CLIVE JONES

WRITTEN REPRESENTATION

HIGHWAYS ENGLAND'S RESPONSE

Drawing file: TR010019 / TR010019-003782-Vegetation Clearance Sheet 6.pdf

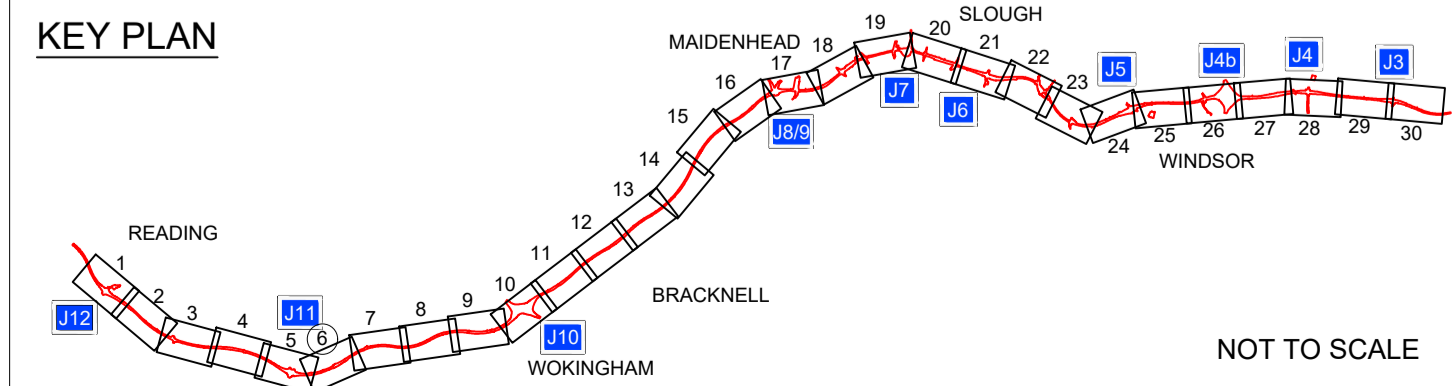
6. *“There are also areas of waste land along the side of Lower Earley Way where earth bunding could be erected. The added advantage of this is it will the astatic look of the area. Residents wont be able to see the M4 and hopefully will hear less of it.”*

- 6.1 The section of the Scheme adjacent to Lower Earley Way is for the most part contained by existing intervening vegetation and a noise barrier, as illustrated in the drawings Vegetation Clearance Sheet 6 and the Environmental Masterplan Sheet 6 in Annexes A2 and A1 respectively to the Engineering and Design Report (Application Document Reference 7-4). As a consequence, the residual visual effects of the Scheme on the adjacent residential properties at Whitely Wood are limited to a small number of properties at Old Whitley Wood (Receptor 3.1.3) with upper storey views over the adjacent noise barrier, as shown in the Environmental Statement (“ES”)

Appendix 8.4 (Application Document Reference 6-3) and Figure 8.2 Sheet 3 (Application Document Reference 6-2). These properties will have a partial view to the proposed Gantry G8-22a resulting in, at worst, a slight adverse visual effect. At this location there is no available land between the M4 and Lower Earley Way to provide earth bunding. Elsewhere along Lower Earley Way, no other visual effects have been reported in Chapter 8 of the ES and consequently the provision of a new bund would not be warranted.
